# Comment for planning application 24/00539/F

<b>Application Number</b>	24/00539/F
<b>Location</b>	Land To The East Of Stratfield Brake And West Of Oxford Parkway Railway Station Oxford Road Kidlington
<b>Proposal</b>	Erection of a stadium (Use Class F2) with flexible commercial and community facilities and uses including for conferences, exhibitions, education, and other events, club shop, public restaurant, bar, health and wellbeing facility/clinic, and gym (Use Class E/Sui Generis), hotel (Use Class C1), external concourse/fan-zone, car and cycle parking, access and highway works, utilities, public realm, landscaping and all associated and ancillary works and structures
<b>Case Officer</b>	Laura Bell
<b>Organisation Name</b>	Stephen Turpin
<b>Address</b>	21 Chorefields,Kidlington,OX5 1SX
<b>Type of Comment</b>	Objection
<b>Type</b>	neighbour
<b>Comments</b>	<p>1) I object to the planning application for a football stadium on the 'triangle site' to the south of the Kidlington Roundabout. Below are my comments and concerns. Where I have made comments with respect to the proposed stadium this should not in anyway be construed as supporting the application. Whilst I have only been

Figure 14.2 - Existing Drainage Ditches

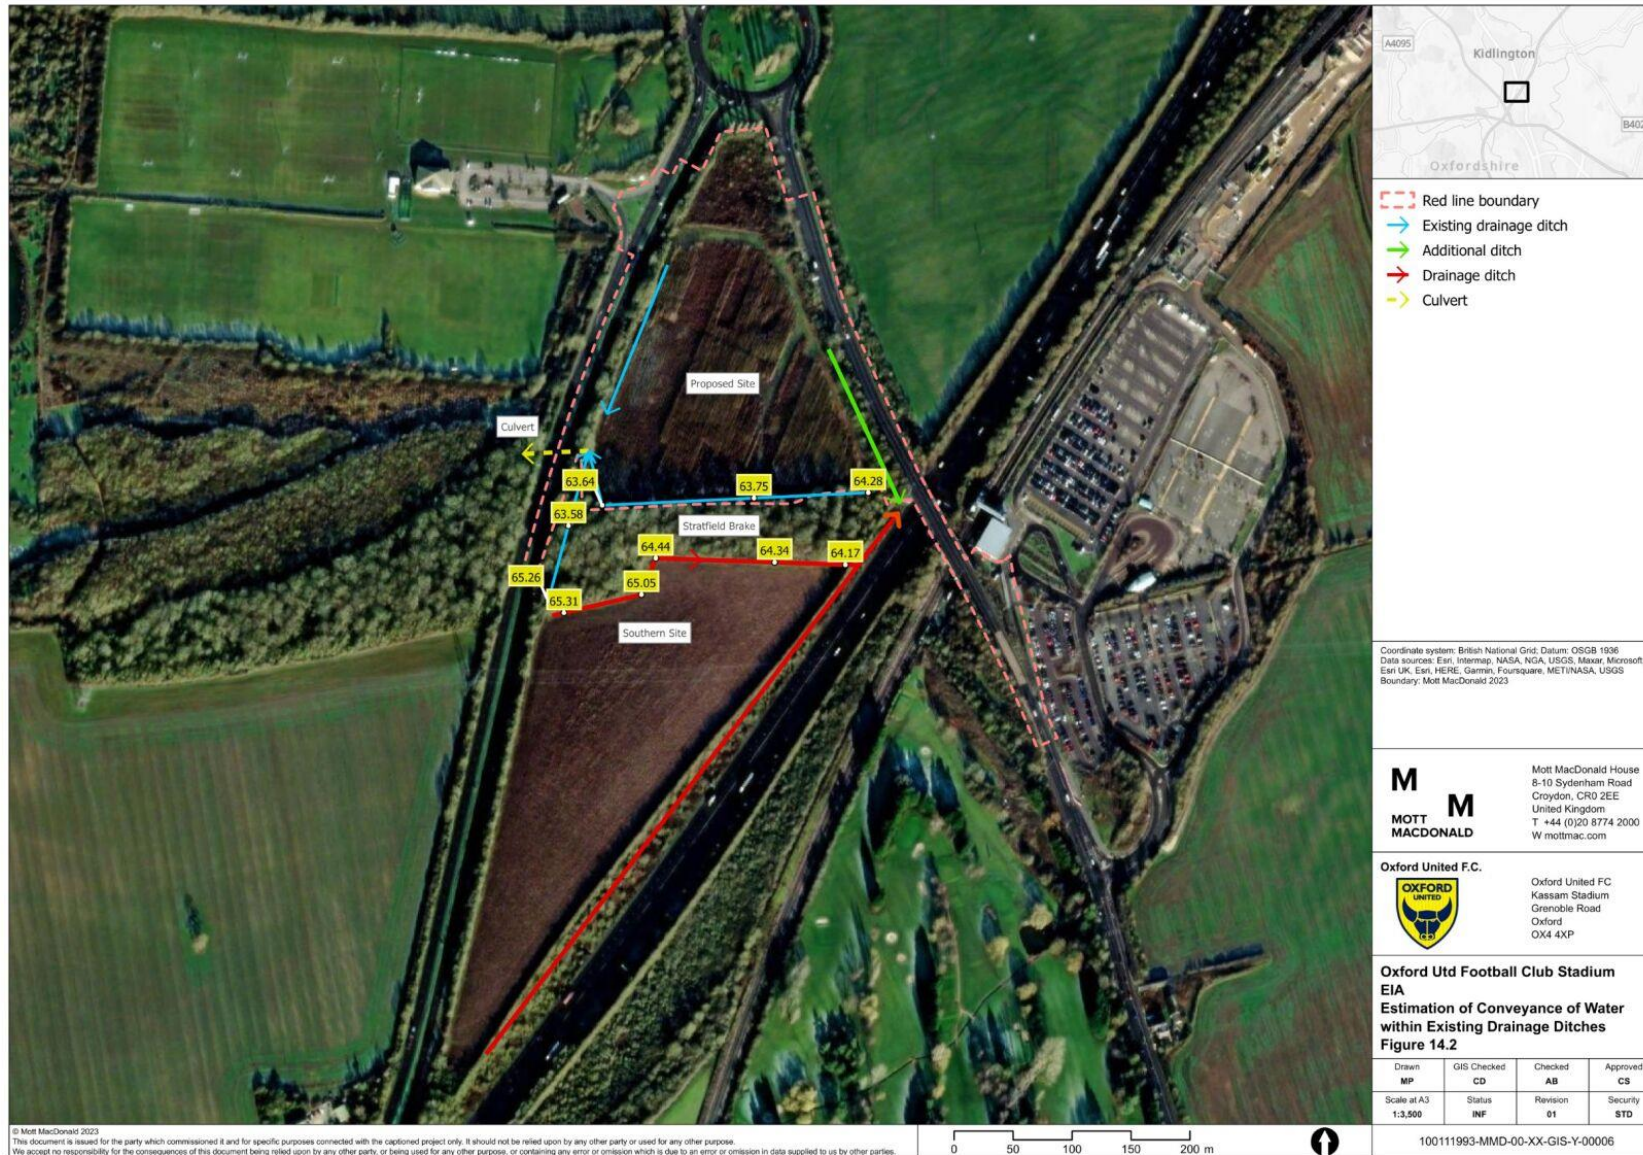
2) The discharge of surface water is dependent on a large diameter culvert under Frieze Way which is significantly blocked. Before a consent is granted OUFC need to demonstrate that there is an unobstructed route to a suitable watercourse able not only to accommodate the correct greenfield run-off rate from the development but also able to manage the increased volume of water that enters the watercourse in a much shorter period than is likely to be the case with the existing greenfield site. OUFC need to demonstrate that there surface water discharge will not increase downstream flooding to third parties. This will require more detailed studies and consultations to prove there is an outfall to the receiving watercourse.

3) OUFC surface water strategy assumes that the large diameter culvert will be cleared out by the landowner and future maintenance will be undertaken by them. As OUFC have no direct control of the culvert they cannot rely on either the culvert being cleared out and in particular that future maintenance will be carried out.

4) Correspondence with OCC Highways indicates that the existing large diameter culvert under Frieze Way may be a highway asset. By normal convention a highway asset will not be able to receive surface water discharges from a private development site. This is alluded to by OCC in that they have suggested a new culvert would be required under Frieze Way into a suitable downstream watercourse. OUFC have therefore not demonstrated that there surface water drainage proposals have a viable outfall. Before any planning consent is provided OUFC need to demonstrate there is a technical solution to convey surface water from there site to a suitable watercourse within land that they have control over. If the delivery of their outfall requires consent from another land owner then OUFC must provide details of the land owners consent. Without the said consent the application should be rejected.

6) The Mott McDonald report acknowledges there is some uncertainty about the viability of a culvert under Frieze Way being suitable for the site discharge. They have discussed an alternative strategy which seems to rely on using Highways England highway drainage. This strategy would not work as Highways England would not agree to receive a discharge of surface water from a private drainage system.

Figure 8.1: Proposed Catchment Areas

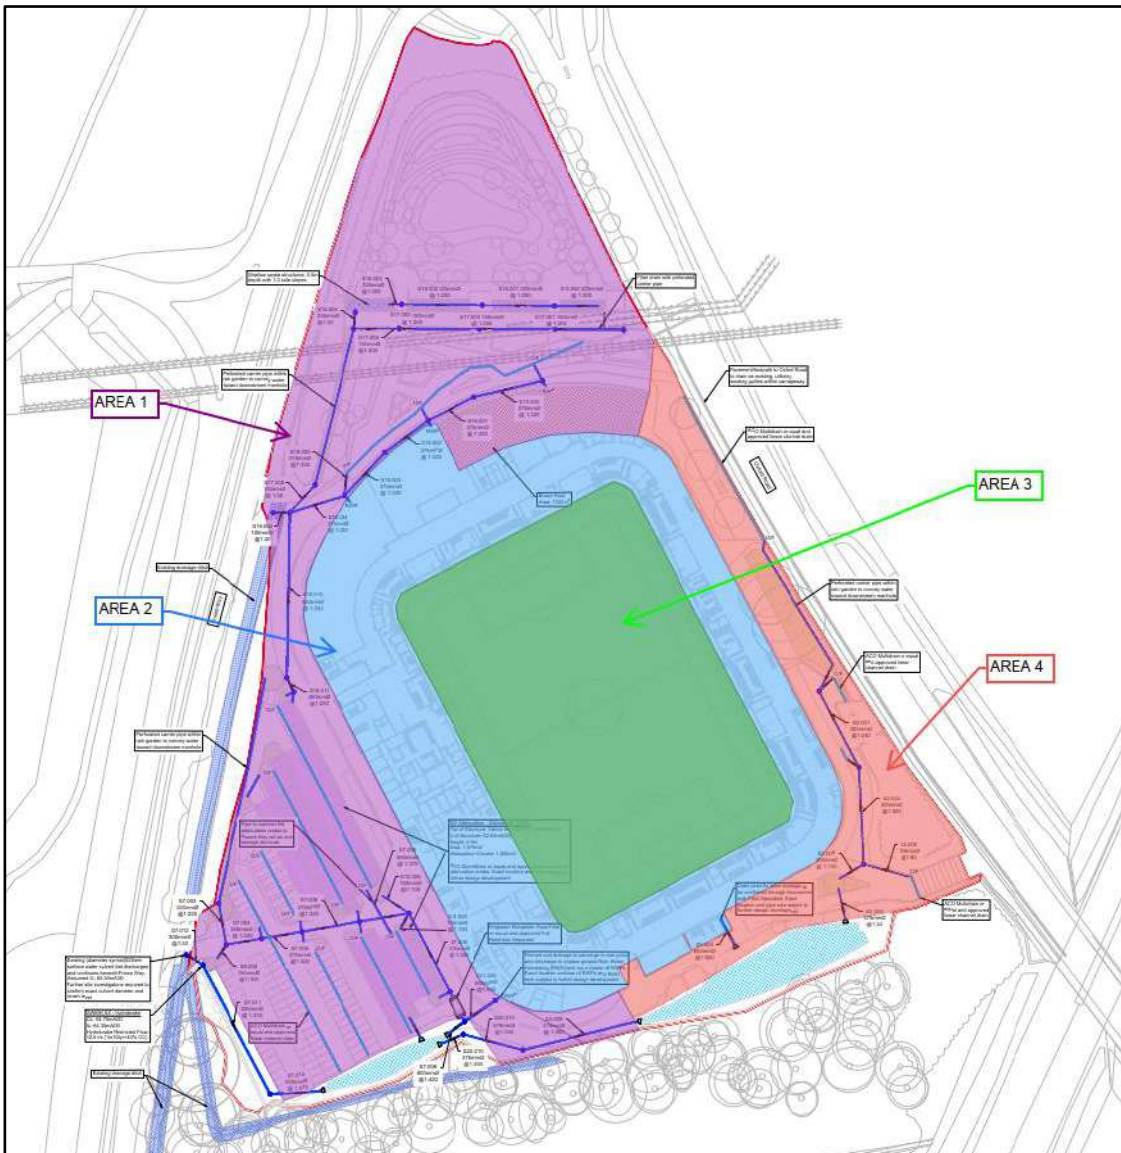
1) From the Flood Risk and Drainage Strategy report it is evident that the OUFC drainage proposals are not sufficiently developed to prove they have the means to dispose of foul and surface water from their proposed site. Without a detailed scheme which demonstrates clearly how foul and surface water will be disposed off the development should not be consented.

5) Whilst OUFC have considered the circumstances when the hydro-brake is blocked, this would only be a temporary problem until the hydro-brake is cleared or replaced. Being unable to discharge water from the site due to the culvert being blocked could be a much longer term problem. Water overflowing onto the car park and roads for anything other than a very short period would not be acceptable particular if the parking areas are used for disabled parking.

7) Given that the underlying soils are unlikely to accommodate infiltration systems OUFC have not demonstrated that they can manage there surface water and until they have a proven they can discharge to a suitable receiving body without flooding third party land consent should not be provided.
